Subject: RE: Planning Consultation on: FP/131/20/PD

Comments from Private Sector Housing:

Application No: **FP/131/20/PD**

Registered: 31st July 2020
Site Address: First Floor Office 44B Summerley Lane Felpham PO22 7HX
Grid Reference: 495759 99872
Description of Works: Notification for Prior Approval under Class O for change of use from a use falling within Class B1(a)(offices), to a use falling within Class C3 (dwellinghouses) -change of use of the existing 1st Floor Office to a self contained Studio Apartment. This application is Not CIL Liable as flat in Zone 4.

Drawing Name:
Proposed Studio Flat Plan
Planning Application Drawing

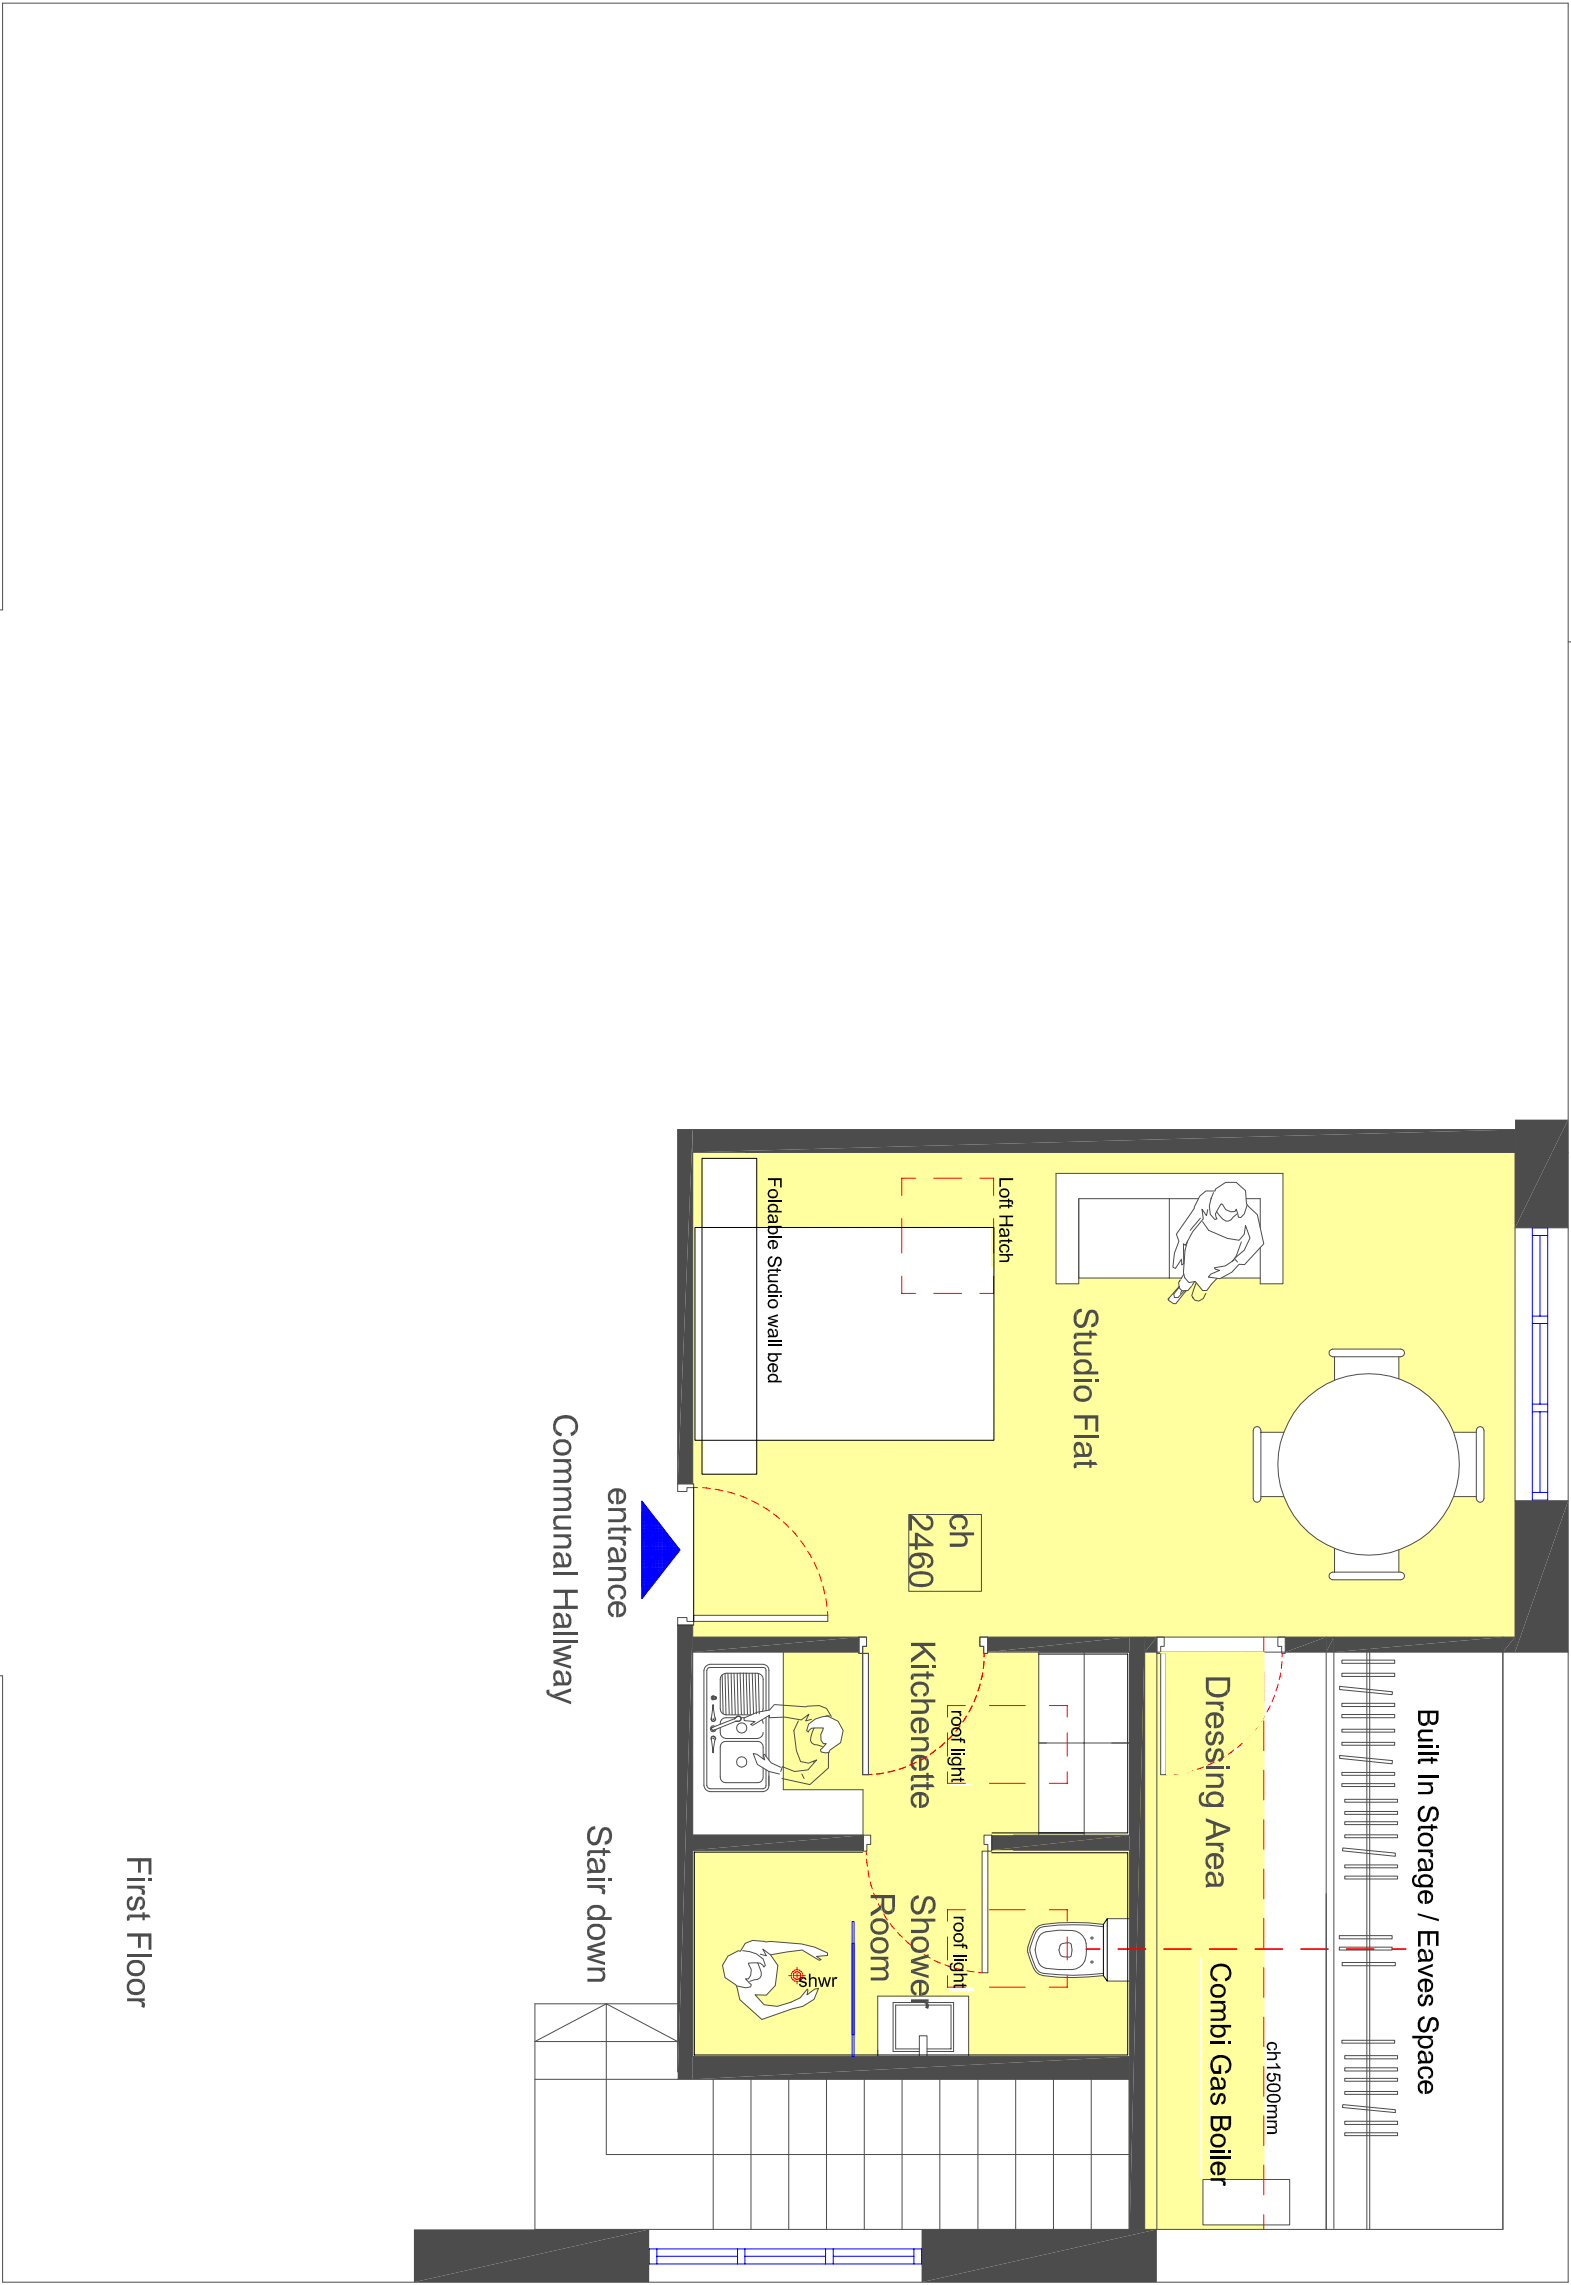
- Appropriate fire precaution facilities and equipment must be provided of such type, number and location as are considered necessary. Guidance on fire safety is contained in the LACORS guidance document – "Housing – Fire Safety, Guidance on fire safety precautions for certain types of existing housing"
- There must be a minimum of 1 hour fire separation between the commercial unit on the ground floor and the residential flats above. Where this cannot be guaranteed, there must be an interlinked system of smoke detection and sounders between the commercial and domestic areas. The under-stairs must also provide 1 hour's fire resistance, in order to protect the single means of escape from the flats above. *
- A mixed fire alarm system, consisting of a

Grade D1 system:

- o interlinked mains wired smoke alarms with integral battery back-up located throughout the escape.
- o Interlinked heat alarms with integral battery back-up located in the entrance lobby of each flat.

- PLUS a Grade D2 system:

- interlinked mains wired smoke alarms with integral battery back-up located in the escape route of each flat, which is not interlinked with the communal fire alarm and detection system.
- interlinked mains wired smoke alarm with integral battery back-up located in the vicinity of the boiler, located off the designated dressing area of the proposed new flat.

***Please see the second comment above, which states that the fire resistance between the commercial and domestic areas must be determined because this will inform what requirements are needed for a suitable fire alarm and detection system.**

- It is considered good practice to provide a fire blanket in the kitchen of the flat if it is to be rented.
- The shower and toilet area is accessed via the kitchen. The applicant should consider that a safer layout would be to have the kitchen located at the furthest end of this area of the flat, or better still, separate the two areas in a way that means occupants do not have to pass through a high risk area to escape in the event of a fire occurring in the kitchen.
- 30min fire resisting escape route, which includes providing a 30 minute fire resisting and self-closing fire door to the entrance of each flat opening on to the communal escape route.
- Ensure the loft hatch within the flat is constructed of 30 minute fire resisting material and includes fire-rated hinges, intumescent strips and cold smoke seals.

- Room sizes should meet the minimum standards as detailed below:

13sqm, excluding size of bathroom and WC facility – suitable for 1 person

15sqm, excluding size of bathroom and WC facility - suitable for 2 persons

- The floor to ceiling height must be at least 2.1 metres from floor to ceiling over at least 50% of the floor area when measured at a height of 1.5metres from the floor and provide sufficient useable space.
- Note with regards to children and how they fit into room size calculations:
Babies up to the age of 1 are discounted
Children aged 1 -10 years are classed as half a person
Children aged over 10 years are classed as a person

- Any bathrooms and kitchens without windows for natural ventilation should have adequate mechanical ventilation.
